From: Andrew Wood
Sent: 07 March 2019 16:38
To: Planning.Responses
Cc: Louise Greene
Subject: FW: 6018: Star Plants Application WA/112/18/CLE - Legal Services Ref: - 7163
Attachments: 6018-001A Star Plants Plan EXISTING A3.pdf

6018: Star Plants Application WA/112/18/CLE

The ADC legal advisors are satisfied that the use is legal however there are three remaining issues relating to various structures on site:

Application Plan SP1.7c

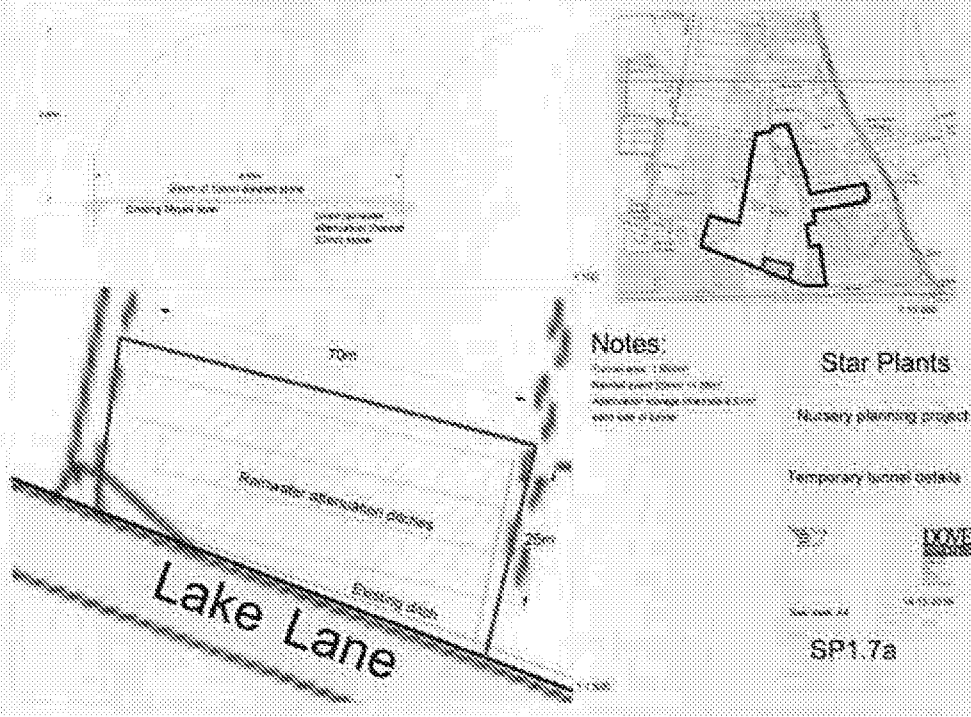
Haygrove 2 Polytunnels: Y/10/17/AG Prior notification under Part 6 for three temporary polythene tunnels. Granted prior approval – decision notice 14.3.2017. Structures must be erected in accordance with the approved details (length, width, height to the eaves and height to the ridge measurements as set out in the decision notice). Evidence: Plan shows 3 tunnels of different lengths and Google earth aerial photo shows tunnels in the position as shown on the plan. It is not clear from the evidence if the tunnels have been erected in accordance with the approved details? Please check the length and width against the scaled plan and determine if the height of the buildings is with is in accordance with approved plans.

We can confirm that the polytunnels have been drawn on the application plan to the same dimensions as the PNO application.

The tree in the 2018 aerial photo makes it difficult to see but the Northern most polytunnel was initially constructed 1 bay short of what was approved, this has since been rectified.

Location Plan 1:5000

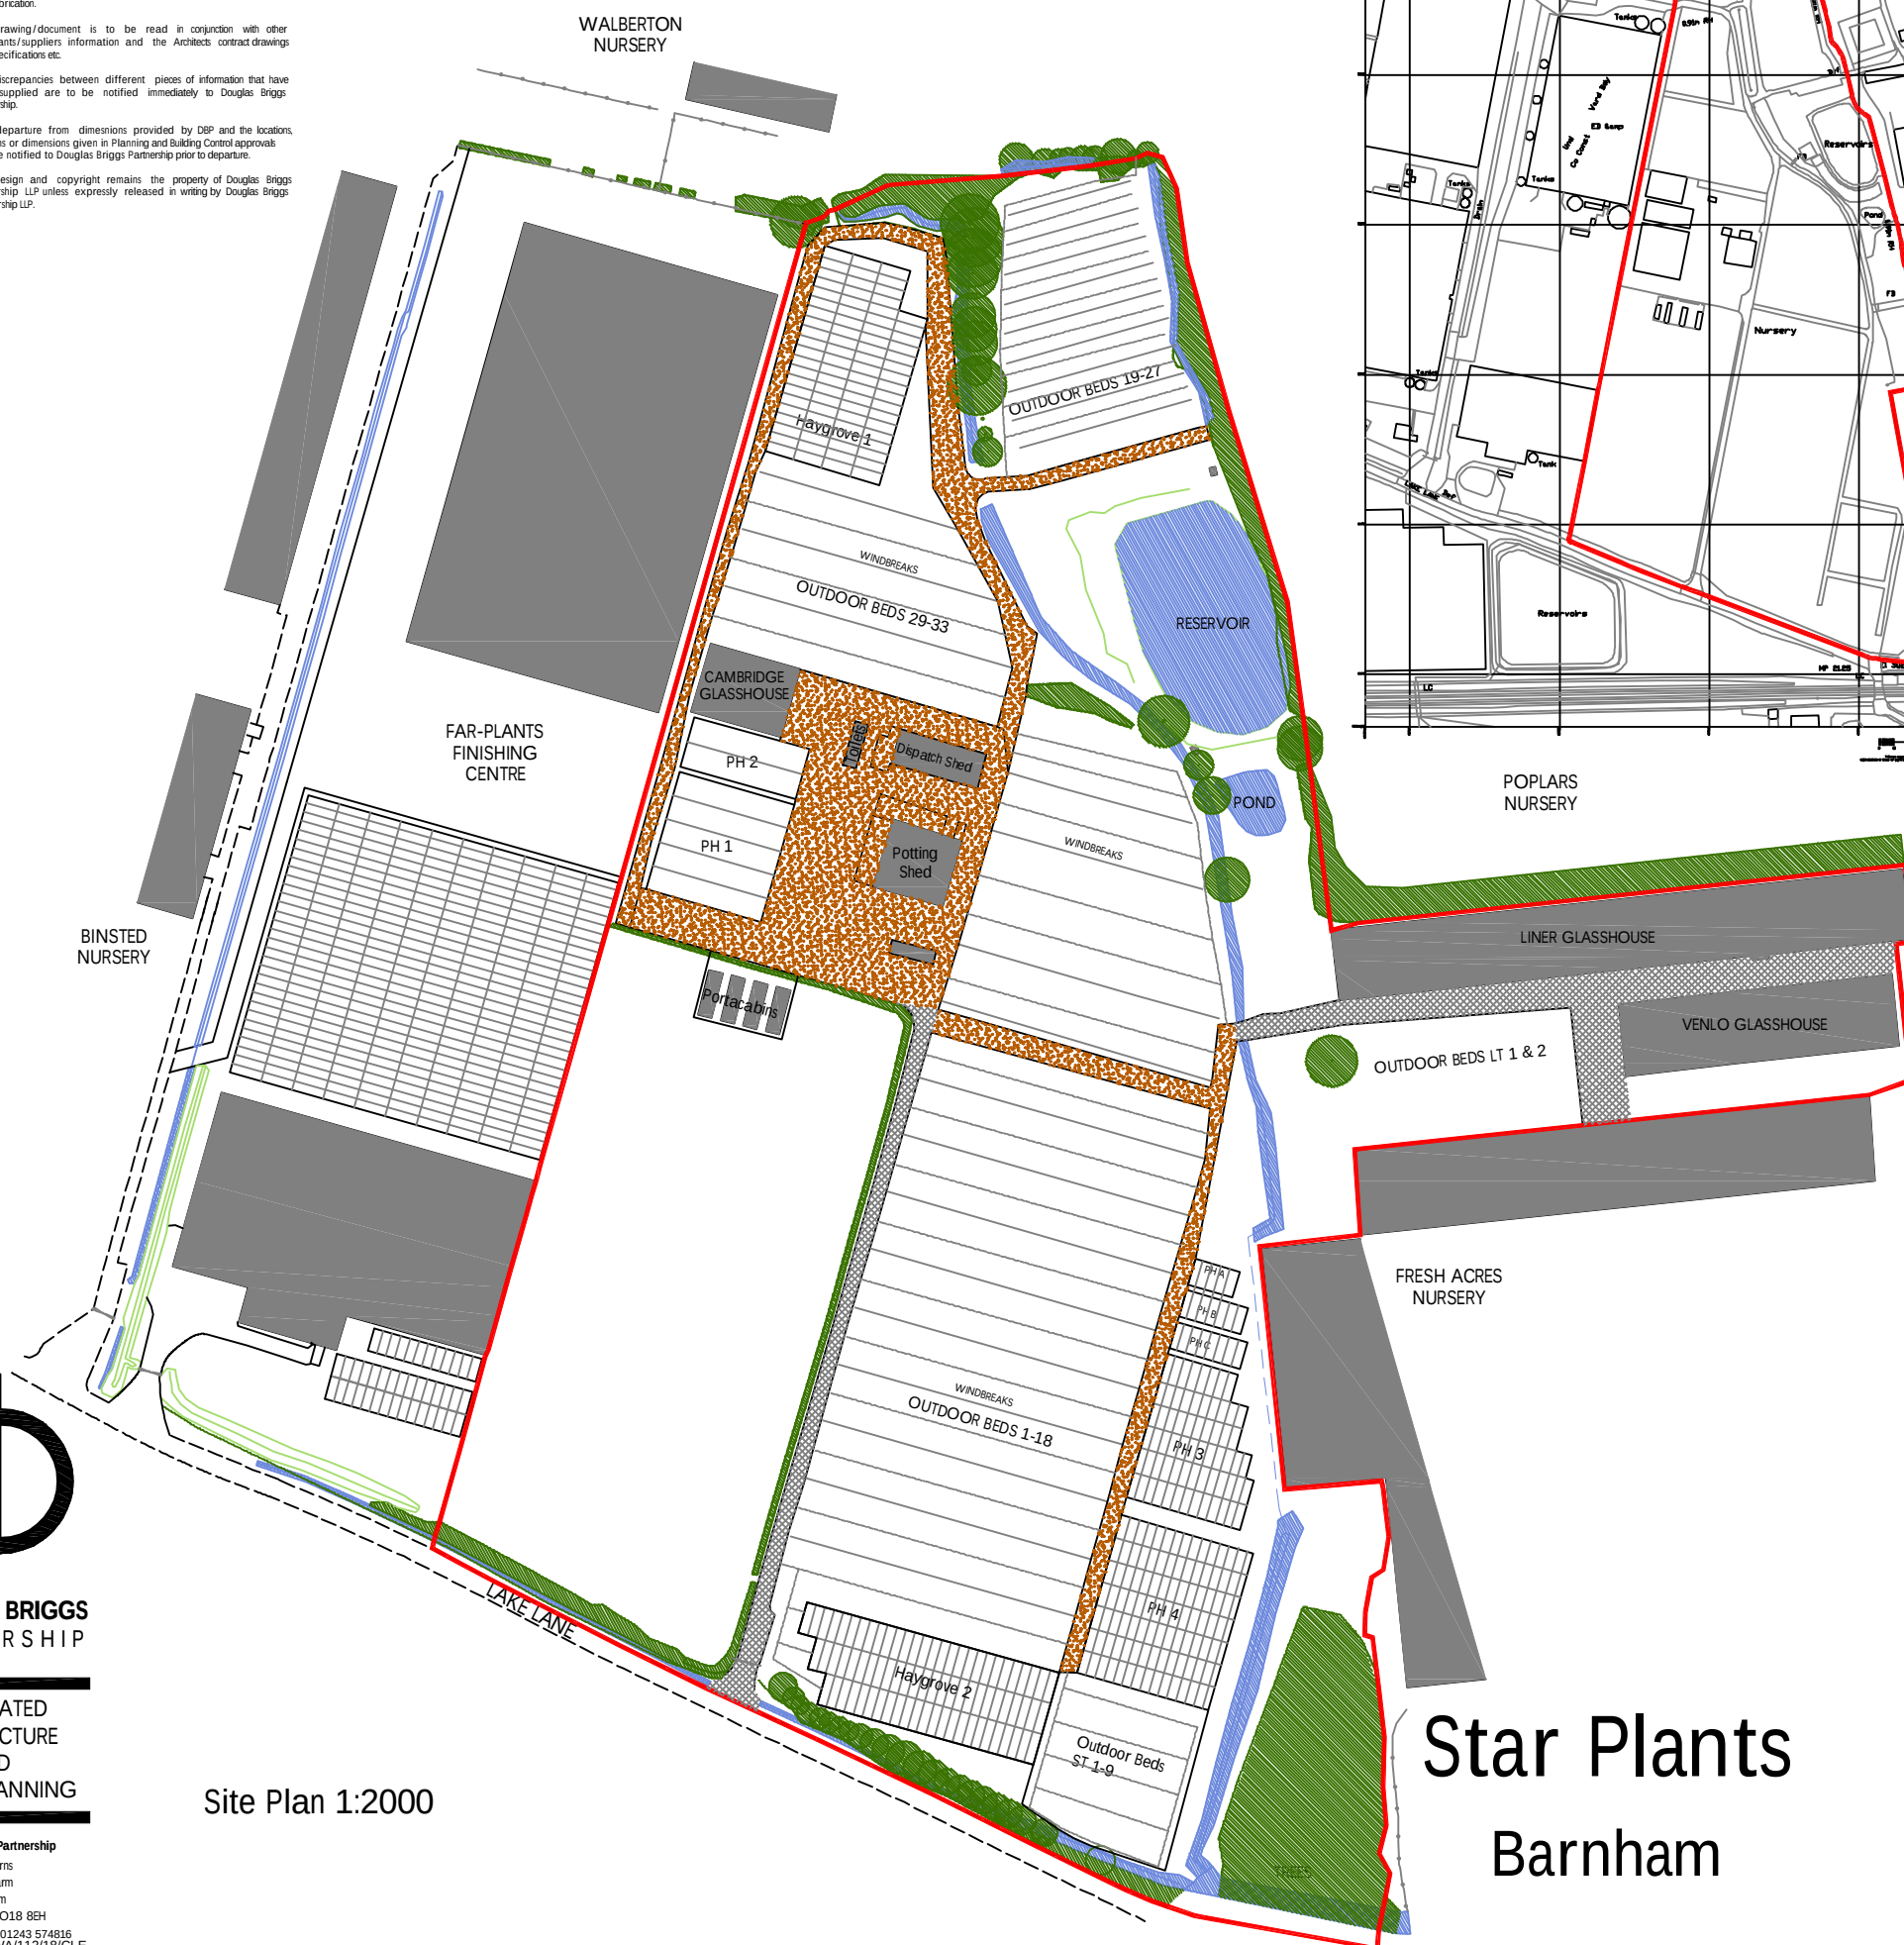
Roads/Farm Tracks: The plan does not identify where the roads are on site. The certificate should be clear where the roads are, so that if any further roads are subsequently built, it is clear which are existing and lawful, and which are new and require prior approval. Looking at the Google Earth aerial photos, I can see a road leading off Lake Lane to the yard, however the table in the Development History refers to more than one road, so clarification should be sought, and you will need to satisfy yourself on the balance of probability as to all of the roads.

We enclose a revised plan that shows the surfaced roads and tracks.

The plan indicates the tarmac road from the access and concrete track over the bridge to the Linear and Venlo Glasshouses.

The plan also indicates the gravel access tracks around the planted beds

Each of these conform to the layout shown on the 1989 OS map extract and aerial photos

The central gravel yard area appears to have expanded since the 1989 OS map but is clearly identified on the 1992 OS Map and in all the Aerial photos back to 2001.

We are therefore satisfied that on the balance of probabilities, all of these roads and tracks have been in existence for more than 10 years

OS Map extract – Lake Lane 1989

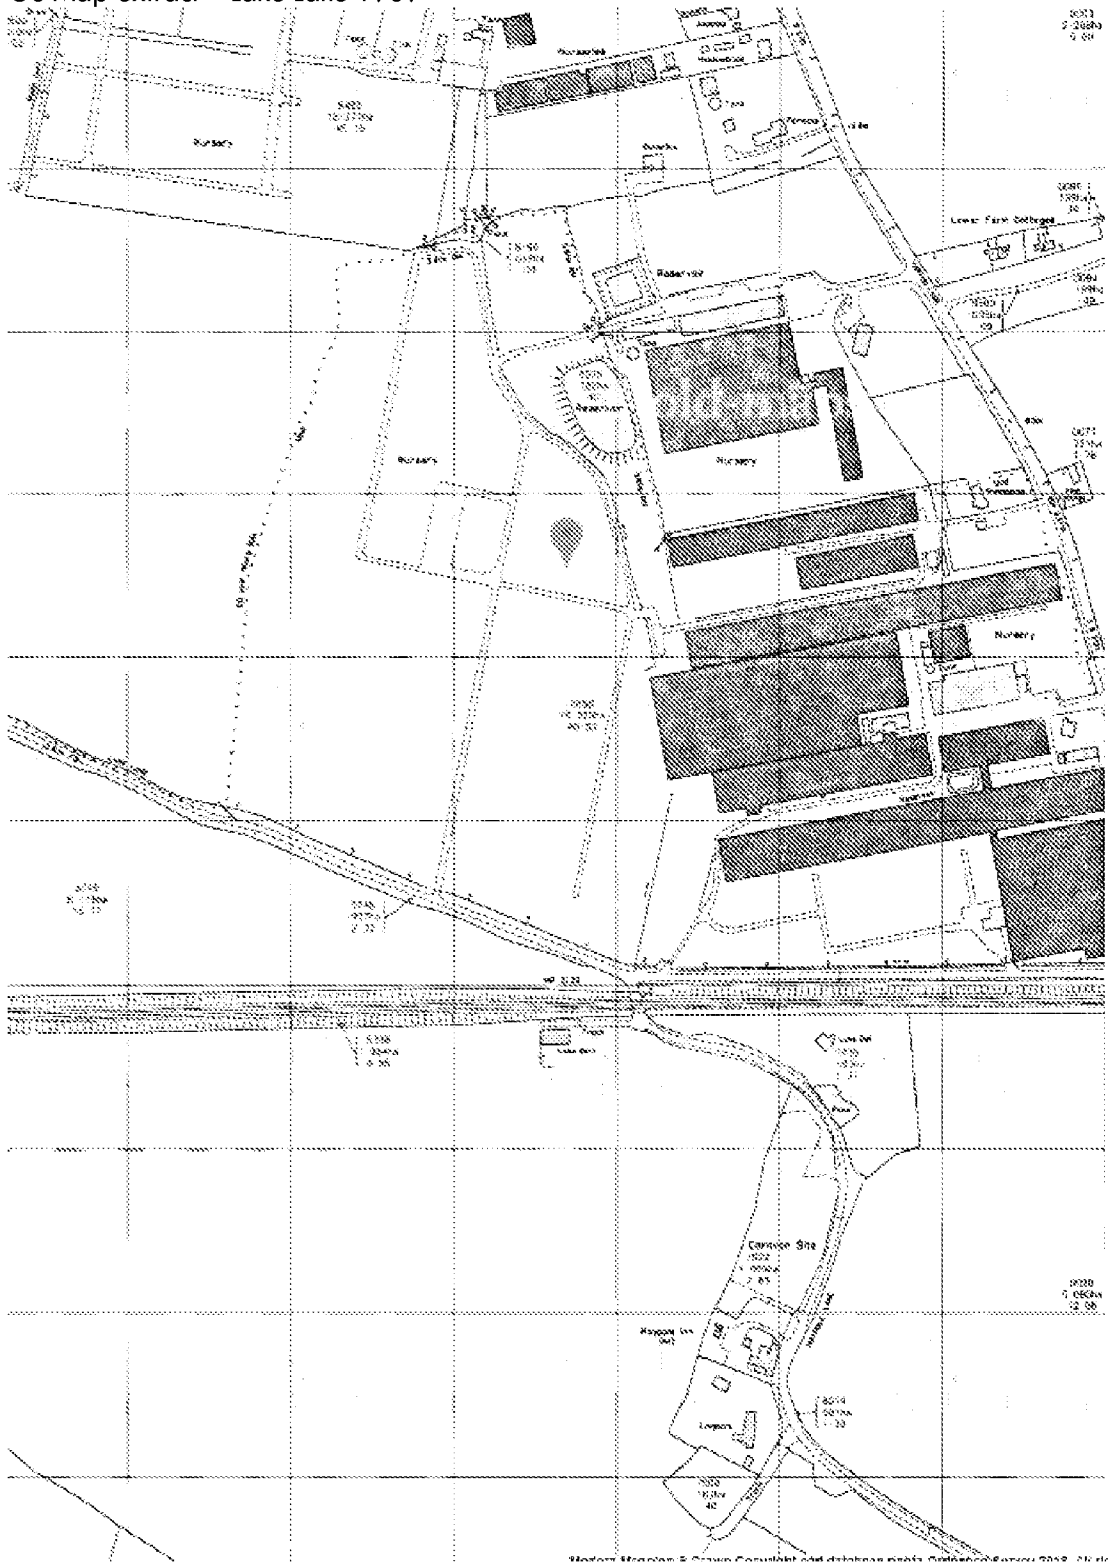
The Reservoir: It is not clear from the evidence provided of the aerial photos if the Reservoir remains in situ, as shown on the OS Map 1989 and 1992. It is clear from the aerial photos that there is a shape where the reservoir is purported to be, however the area appears on a number of photos to be trees/green landscape. In consideration of this, we met on 8.2.19 and looked together at ADC GIS historic maps and we were both satisfied that there is a reservoir in place as shown on the plan, looking at maps in 2010 and 2018. I would suggest you add that evidence to your file records, as the applicant's evidence is not sufficiently precise and unambiguous to justify the grant of the certificate for the reservoir, however the evidence on the historic maps is sufficiently precise and unambiguous.

Having been to the site, we can confirm the reservoirs do indeed remain in situ.

It is worth noting that the level of the water changes and as the trees grow on the banks, they obscure the edges of the reservoir in the aerial photos.

The Aerial photos do correspond with the OS map evidence so I trust that these can be included within the certificate.
